Recommendation: Approve

Applicant: Persimmon Homes Ltd (South Midlands)

Proposal: Reserved Matters to 14/01932/OUT: Parcels 1 and 3 for 237 dwellings - appearance, landscaping, layout and scale

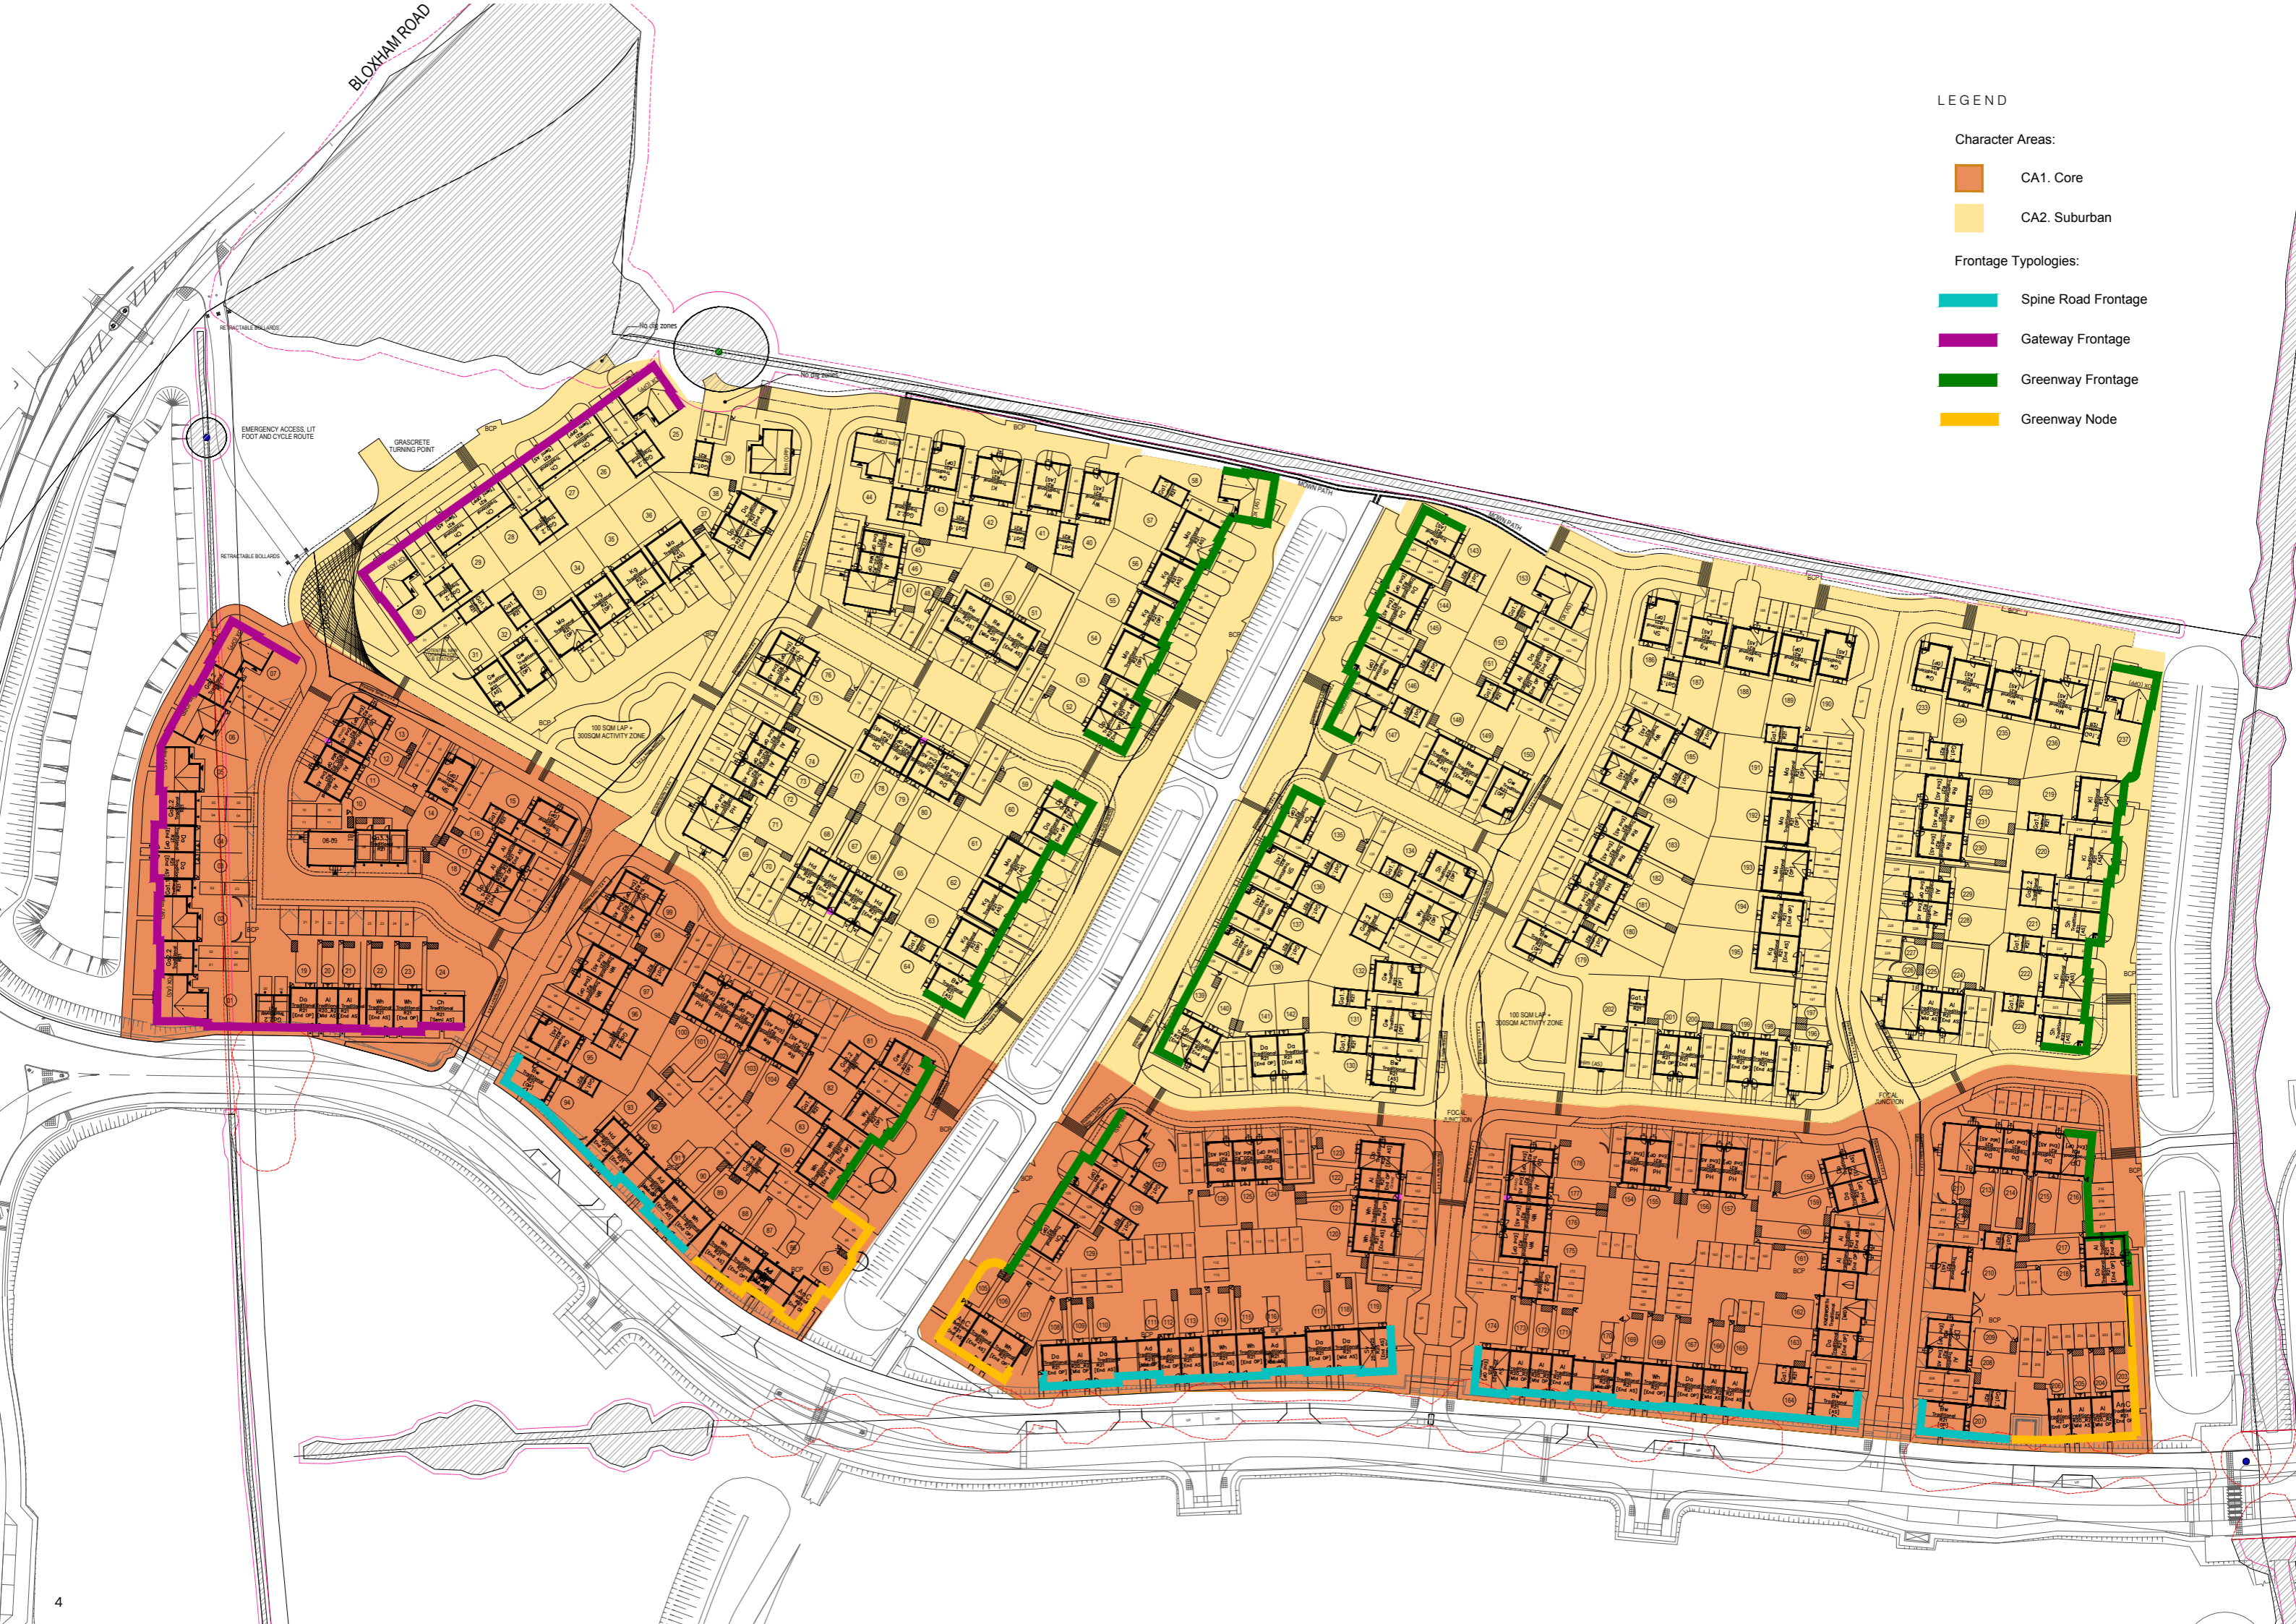
- 8.14. In terms of the entrance into the development from the newly constructed Bloxham Road roundabout, the first block of development is important in setting the scene for the development and providing a transition between the rural area that is Bloxham Road to the more central area of the development. The design code on pages 94-95 requires this frontage to be constructed in natural ironstone and to reflect the simple urban form to replicate that recently constructed on the adjacent Morris Homes site.

- 8.15. The initial submission, which showed a series of detached and semi-detached units with double garages between, was not considered to accord with this vision and therefore not acceptable. Furthermore, the garages were rear facing onto this frontage with false or blank garage windows, which were not appropriate for this important frontage. It was also considered that the built form should appropriately turn the corner and continue along the spine road frontage. Plots 78 and 79 were placed at odd angles, resulting in exposed wide gable spans and parking areas visible to the main frontage, open space and public right of way. The resultant wide corner also created an unfortunate vista down the side street, which was dominated by parking and the proposed sub-station. The applicant was advised that this whole frontage block required re-consideration.

- 8.16. Following several meetings and discussions, the frontage block was revised and is significantly improved. The layout now proposes a much better built frontage comprised of detached and semi-detached units with garages between constructed in natural ironstone. It is regrettable that plots 1-7 are accessed from the rear rather than the front as this has created an unfortunate rear access at the back of this block, accessed from the internal road. However, Persimmon have sought to improve the rear parking area significantly by re-designing it to include dwellings that front this area providing surveillance and activity and a mews type street, with parking broken up with tree planting. It is considered that on balance this solution is acceptable.
